Office of
Environment
& Heritage

DOC11/28120; File No. FIL10/11970
Peter Hughes (02) 4908 6819

**RE: Comments on Environmental Assessment for Newcastle Gas Storage Facility,
Tomago – MP10_0133**

ATTACHMENT A - OEH REVIEW OF THE ENVIRONMENTAL ASSESSMENT

Figure 6.3: CALMET Generated Wind Rose for the site

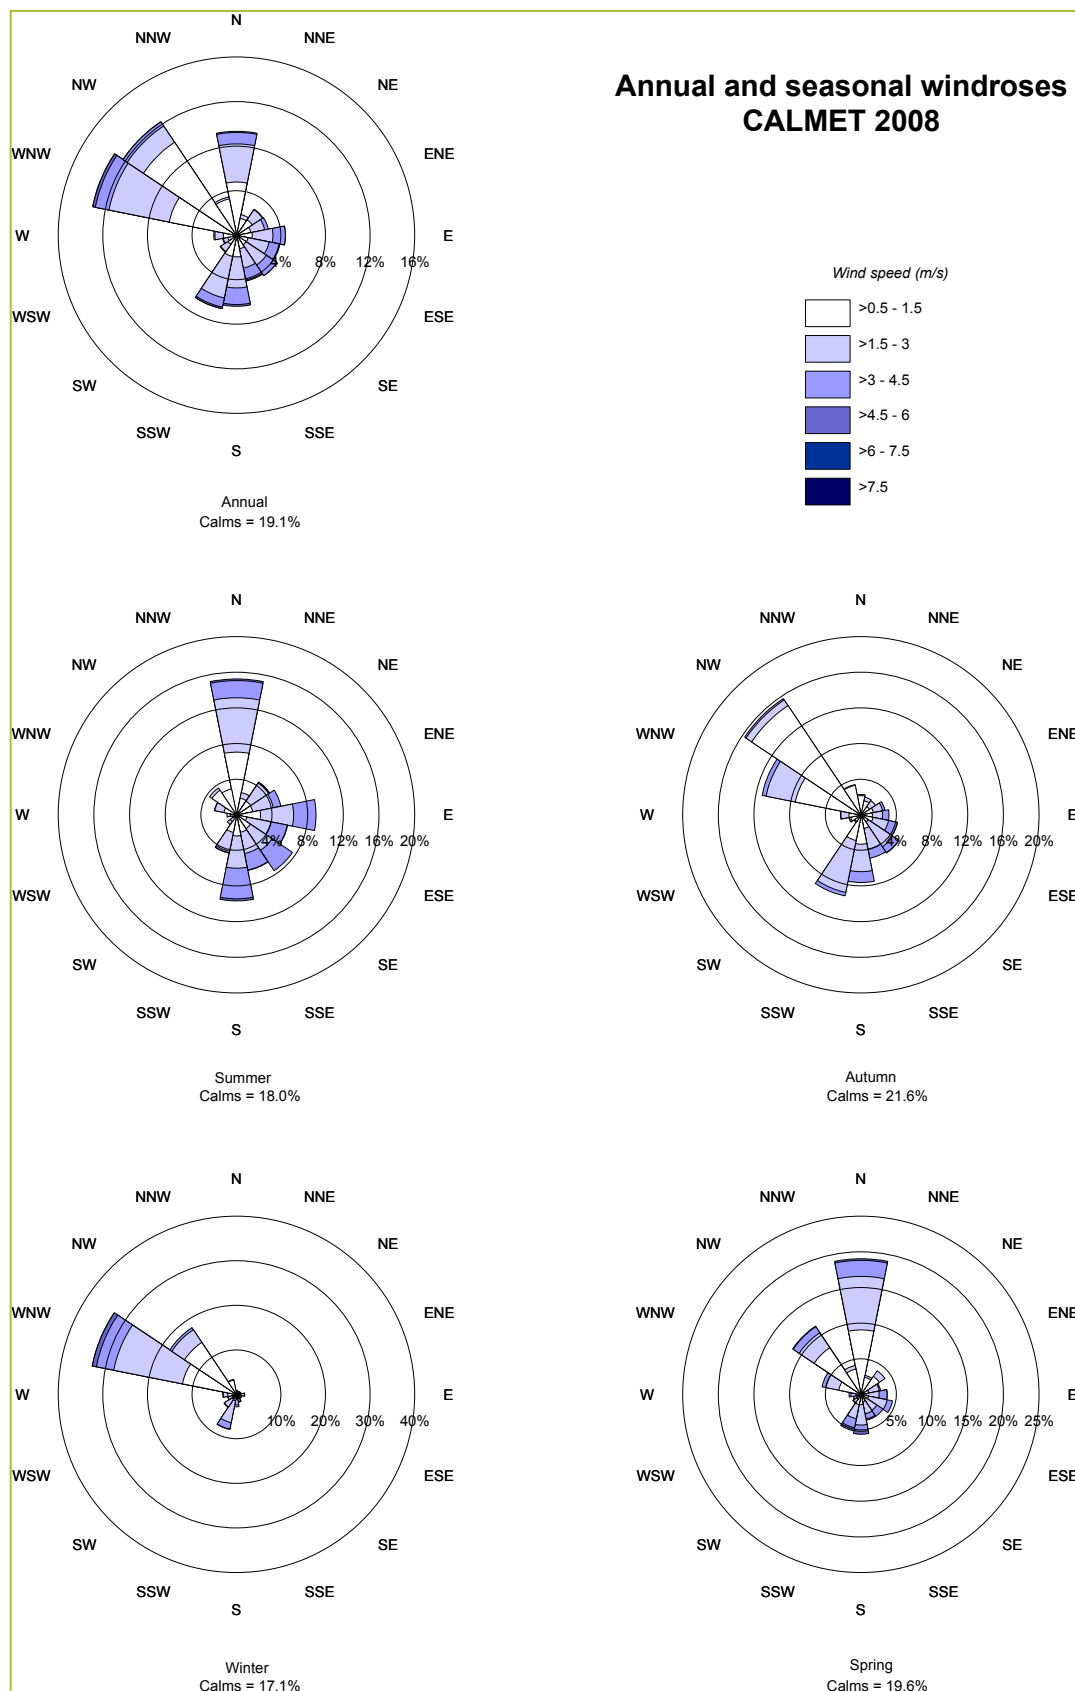
- a) The EA or subsequent correspondence should discuss the implications of CALMET's underprediction of calm weather conditions.

The modelling in the EA uses CALMET-generated meteorological data that combines on-site monitoring data and TAPM-generated data. The EA shows that CALMET predicts almost 50% lower percentage of calms compared to observed data, but does not appear to address this discrepancy by exploring how this impacts the modelling outcomes (which showed very little impact from the facility).

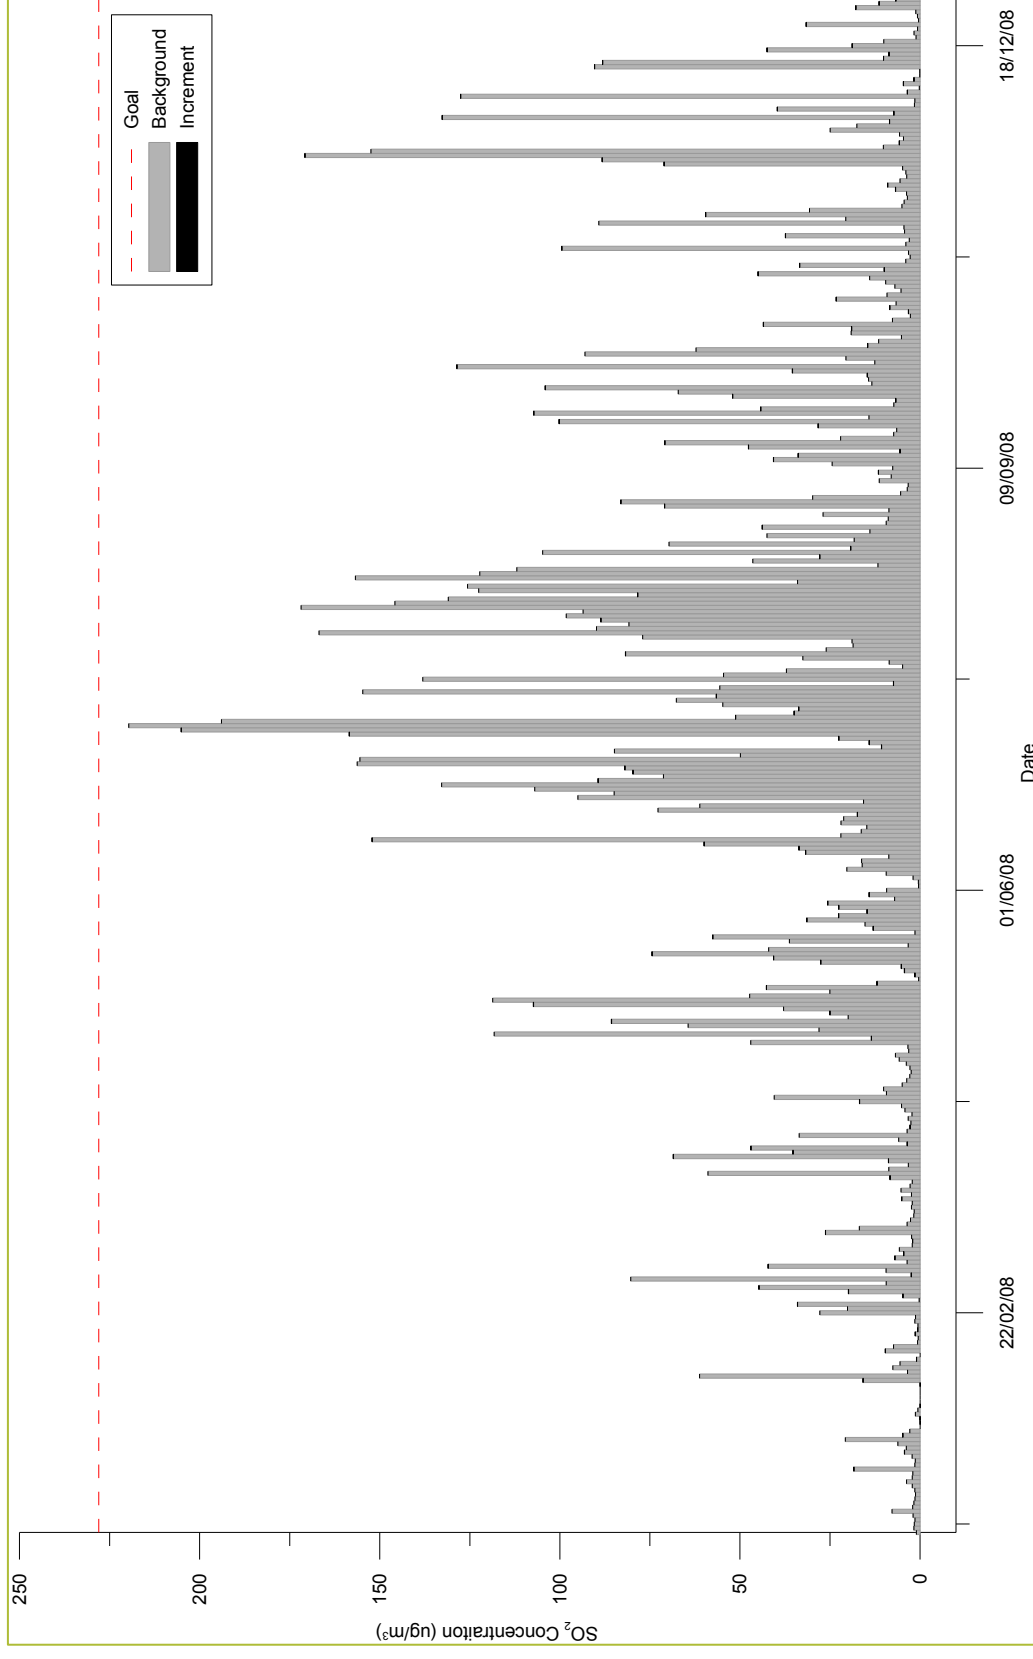
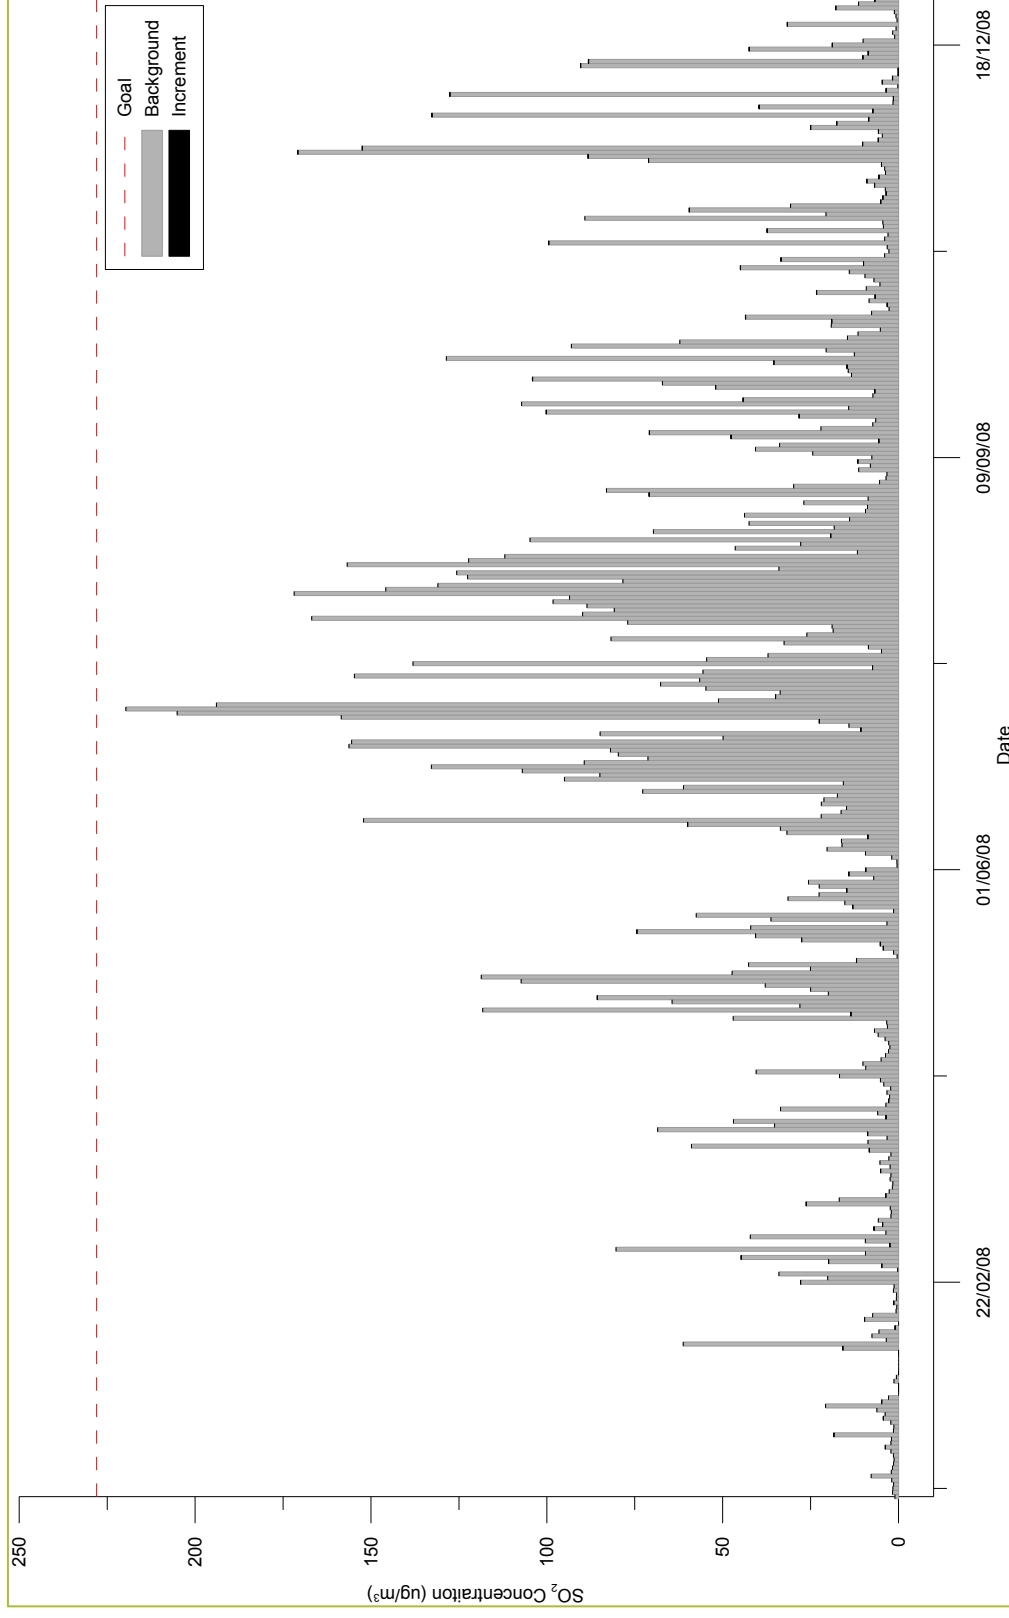
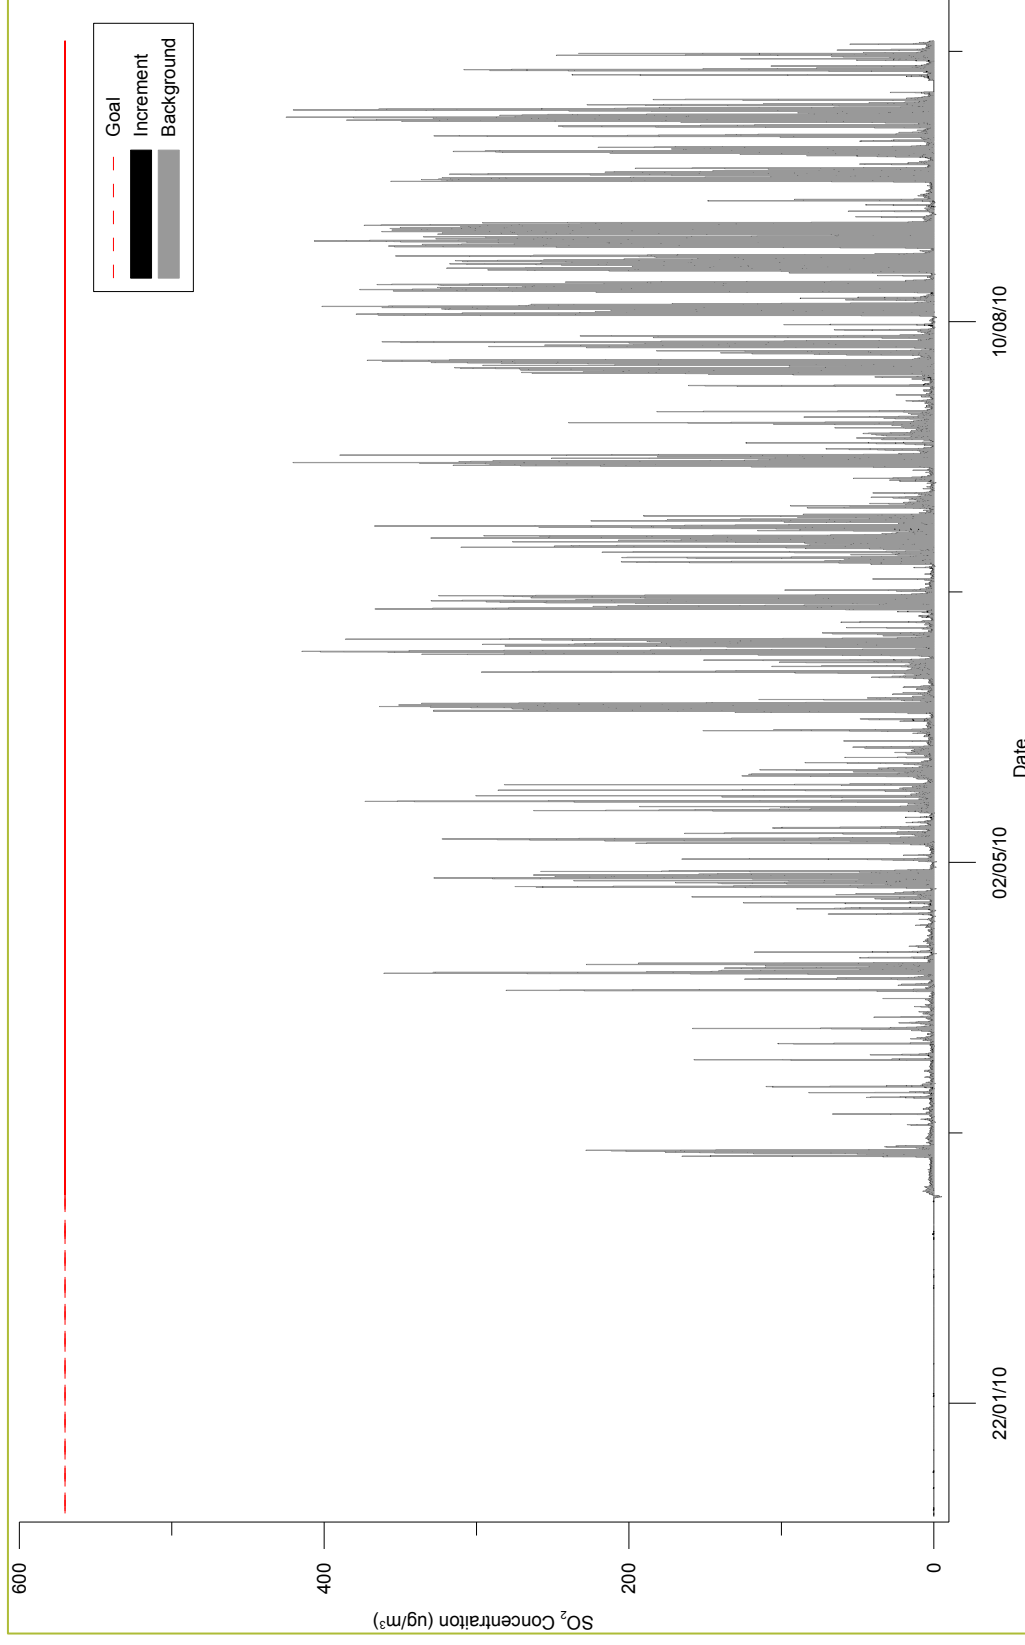
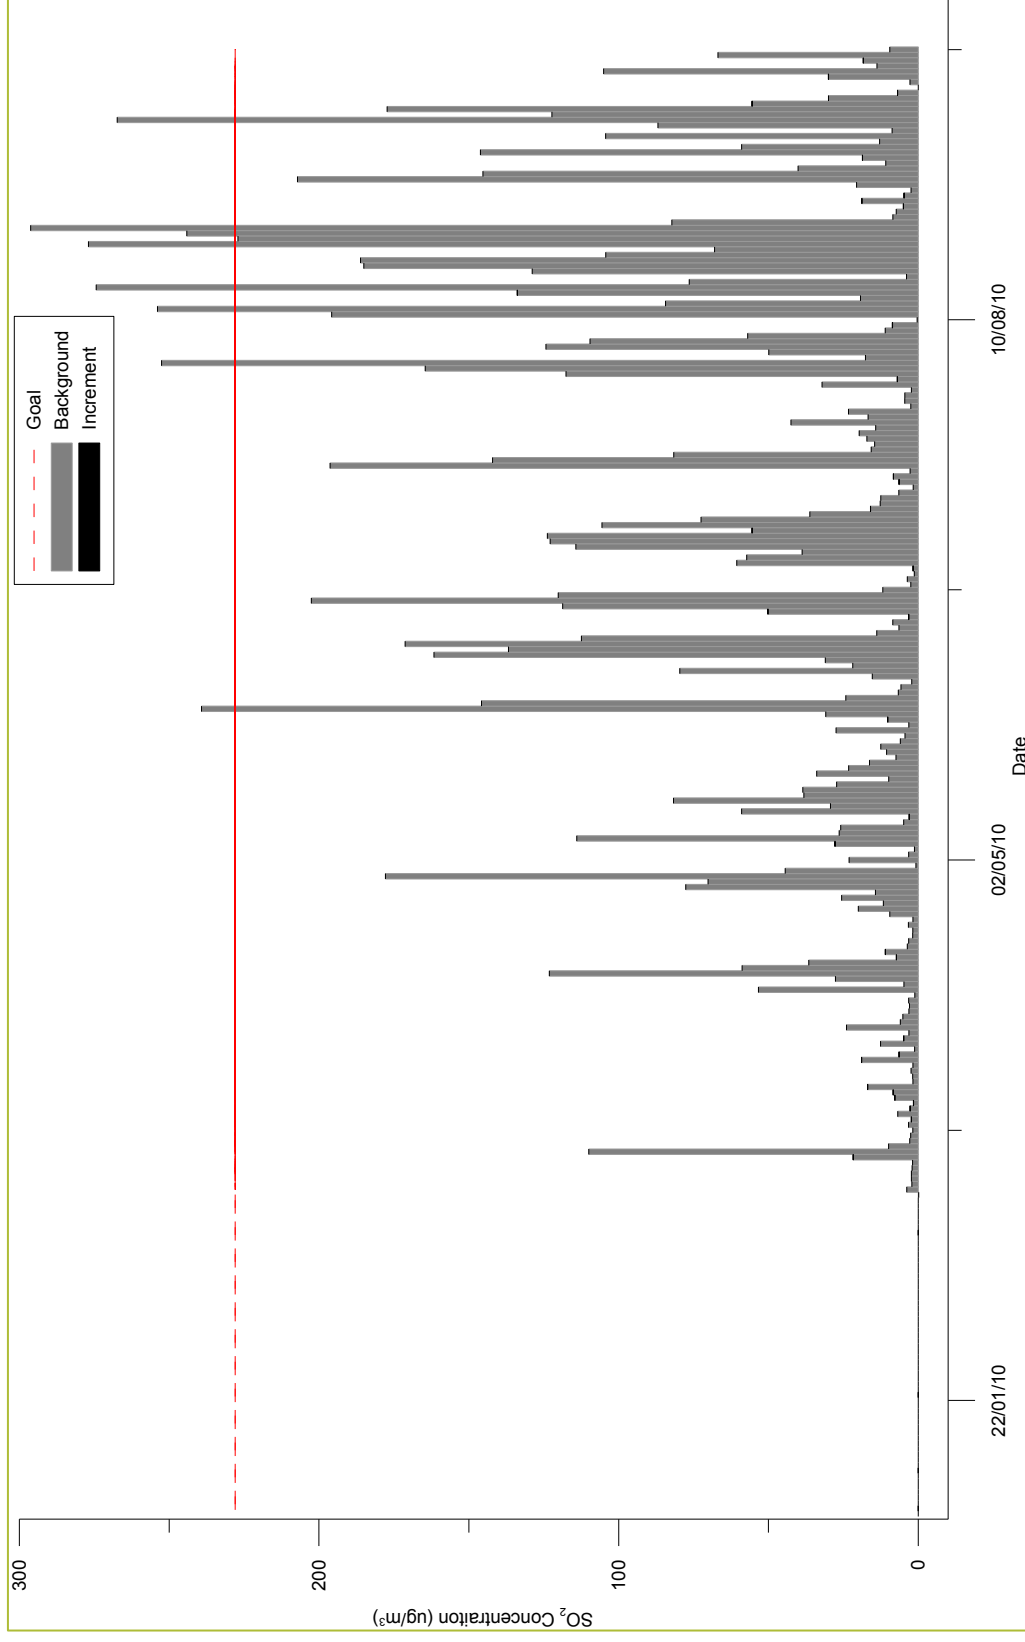
Occasionally, the 24-hr background SO₂ concentration is greater than the OEH goal (of 228 µg/m³) and OEH was concerned that possible cumulative impacts may occur due to the project. However, the SO₂ increment from the LNG plant is very small and wind conditions which result in the higher background concentrations would not result in a combining of high SO₂ from the main source and additional SO₂ from the liquid natural gas (LNG) facility. Therefore, during such conditions, the LNG plant would not contribute to increased cumulative impacts.
